KIRKLEES METROPOLITAN COUNCIL INVESTMENT & REGENERATION SERVICE

DELEGATED DECISION FOR DISCHARGE OF CONDITION A.4 - NOTIFICATION OF A PROPOSED ENLARGEMENT TO DWELLINGHOUSE

Reference no.	2024/HH/91633/E
Site Address	2, Horner Avenue, Carlinghow, Batley, WF17 8DP
Description	The proposal is for erection of single storey rear extension. The extension projects 5m beyond the rear wall of the original dwellinghouse. The maximum height of the extension is 4m, the height of the eaves of the extension is 3m
Recommending Officer	Molly Storer

Rev	Revision		Date
JOB PROPOSED SINGLE STOREY REAR EXTENSION			
ADDRESS 2 HORNER AVENUE BATLEY WF17 8DP MR ISMAIL KHAN			
DATE	SCALE	SHEET	
02/06/2024	1:100	2@A3

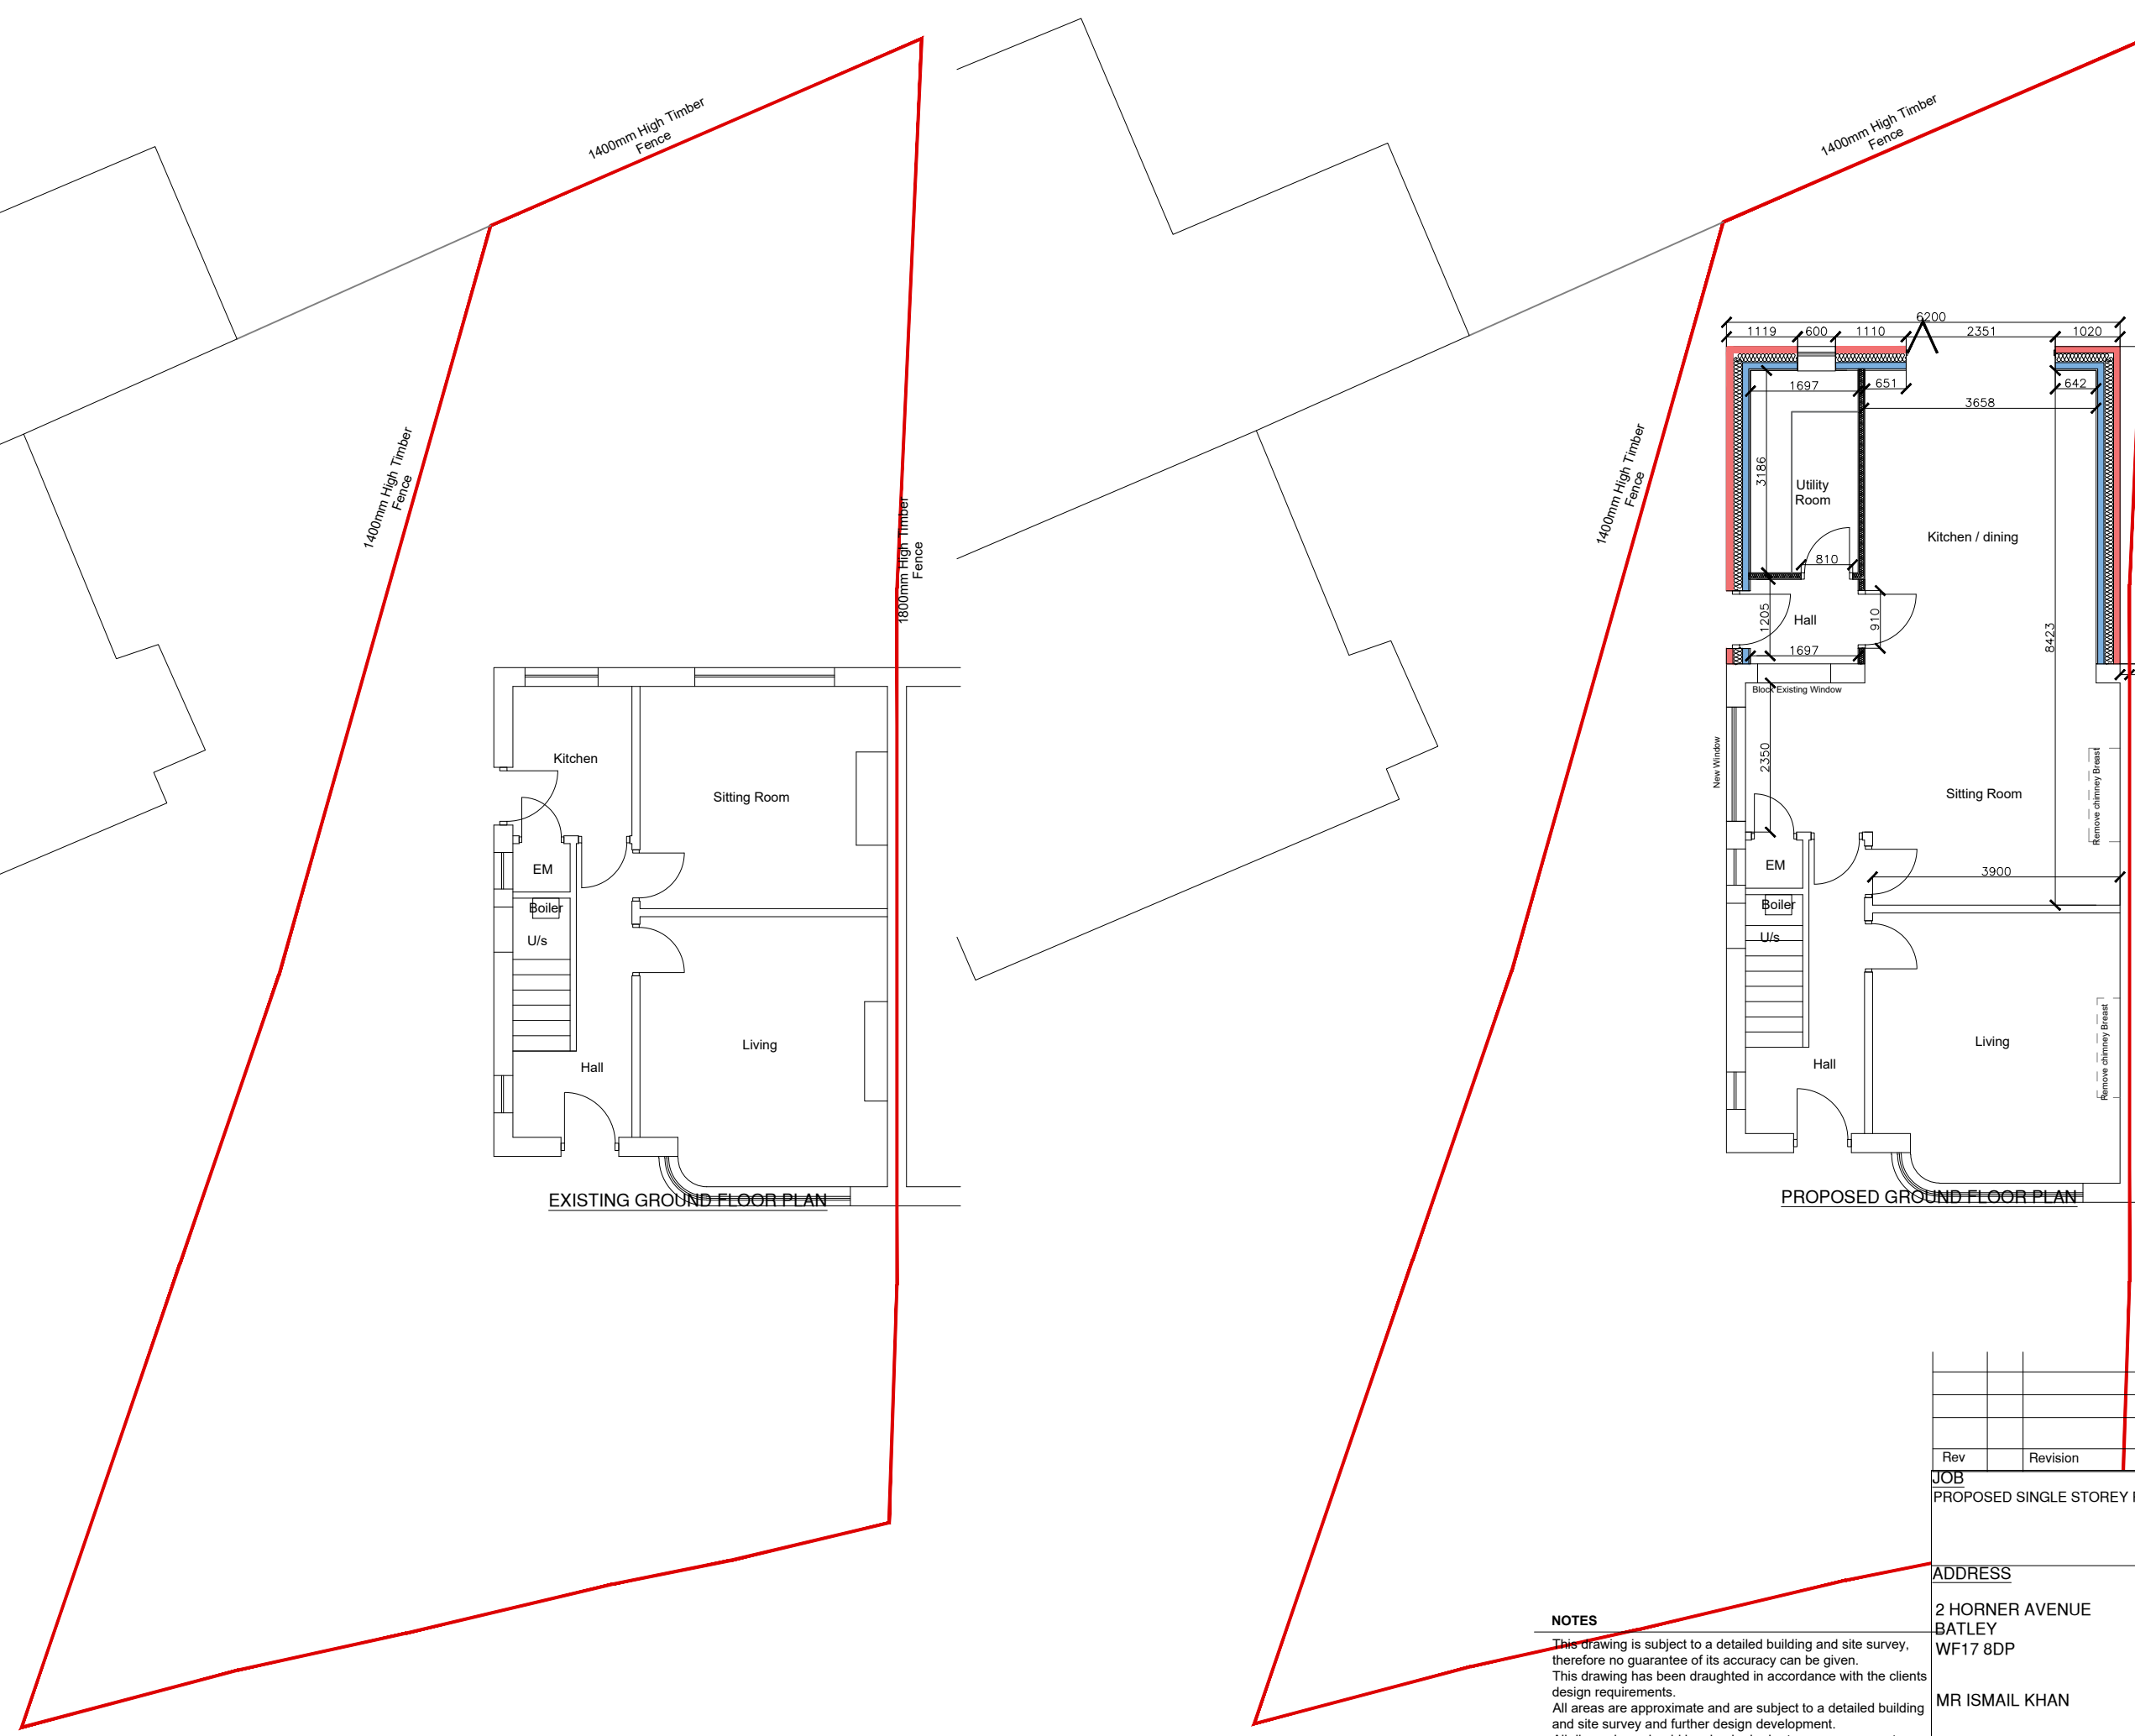
The occupants at No.133 have stated there to be material impacts in terms of overshadowing and overbearing impacting upon their amenity. However, when considering SPD paragraph 5.6, it states that rear single storey extensions should not exceed 4 metres in height and in this instance the extension is no more than 4 metres in height. Although the proposed extension is close to the boundary at the narrowest point and projects further than the recommended 3m for semidetached houses, there is an existing 1.4m fence indicated on the plans along the boundary and boundary fences can be 2 metres in height in any event.

PROPOSED SIDE ELEVATION
(NORTH EAST ELEVATION)

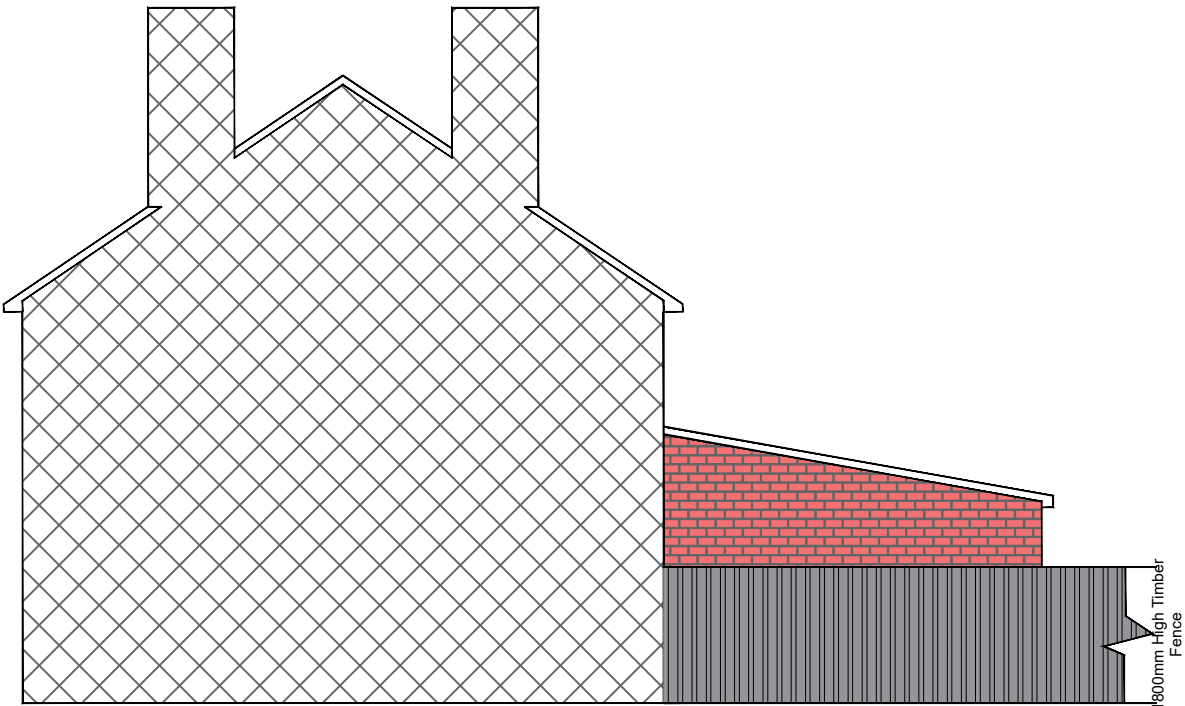
In addition, the agent provided further plans to show the eave height and proposed roof form. This showed a lean-to roof type and a maximum eave height on the bordering side to be 3 metres in order to reduce the impact on the neighbouring garden. Furthermore, there is only a single door in the elevation facing onto this property whereby the majority would be screened by the existing boundary fence.

The proposed floor plans and elevations indicate the wall facing the amenity space of 133 Carlinghow Lane contains a single door opening serving a hallway. If the door consists of glazed panels there may be some opportunity for views into the garden and rear windows of no. 133. However, the door opening serves a hall which in itself is unlikely to cause significant overlooking issues although in light of the close proximity to the boundary the door opening could give rise to overlooking from the kitchen area in the event clear glass is used. Consequently, to reduce the opportunity of overlooking, a condition requiring obscure glass in the door is considered reasonable.

1. Notwithstanding the Town and Country Planning (General Permitted Development)(England) Order 2015 (as amended) (or any Order revoking or re-enacting that Order (with or without modification)), any glazing within the door on the north east elevation shall be obscure glass to the level no less than Pilkington level 5 (or equivalent). The obscure glass shall be retained as such thereafter.

1. Notwithstanding the Town and Country Planning (General Permitted Development)(England) Order 2015 (as amended) (or any Order revoking or re-enacting that Order (with or without modification)), no window or door openings, other than the door as approved, shall be made at any time within the north east elevation.
